# Marine Management Organisation

**Your Reference:** TR030003  
**Our Planning Inspectorate  
Reference:** 20010091  
**Our Internal Reference:**  
DCO/2017/00001

### **RE: TILBURY2 – SECTION 89 AND THE INFRASTRUCTURE PLANNING (EXAMINATION RPROCEDURE) RULES 2010: EXAMINING AUTHORITY’S “RULE 8 LETTER”**

Figure 4-1 Pile diameter vs source level estimator, where line-of-fit is aligned conservatively near the top of the measured data

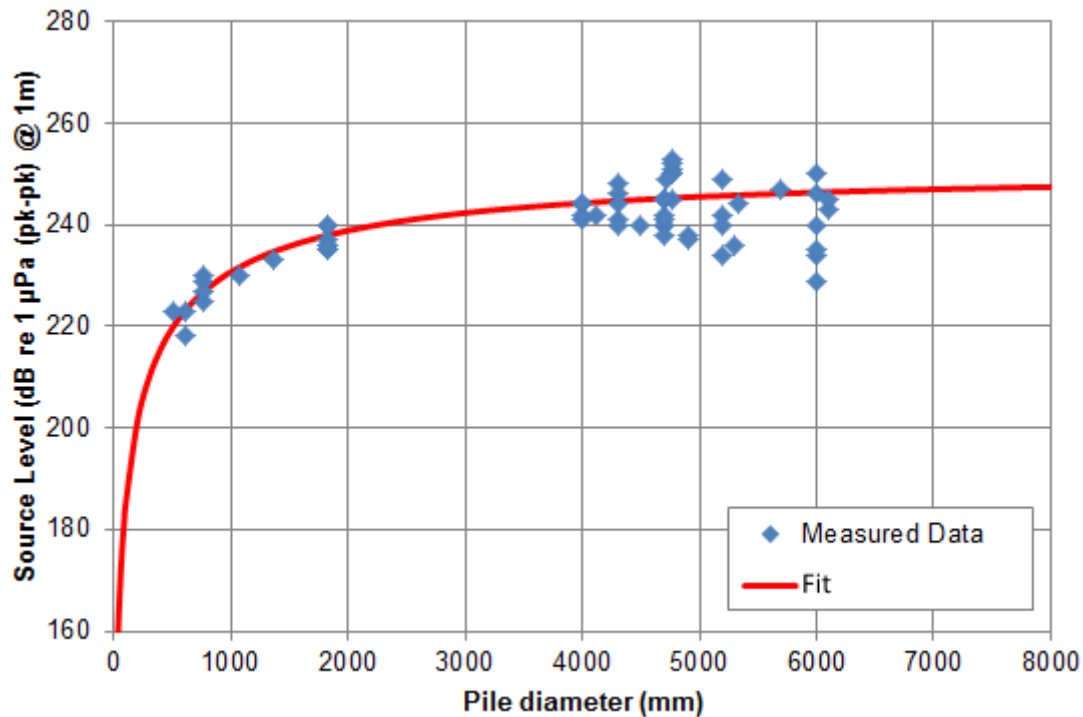
3. Modelling report	
3.1. It is presumed that the source levels at 1 m (as shown on Figure 4-1) were calculated using measurements in the far field and back propagating, but this is not clear in the report.	This comment is still outstanding.
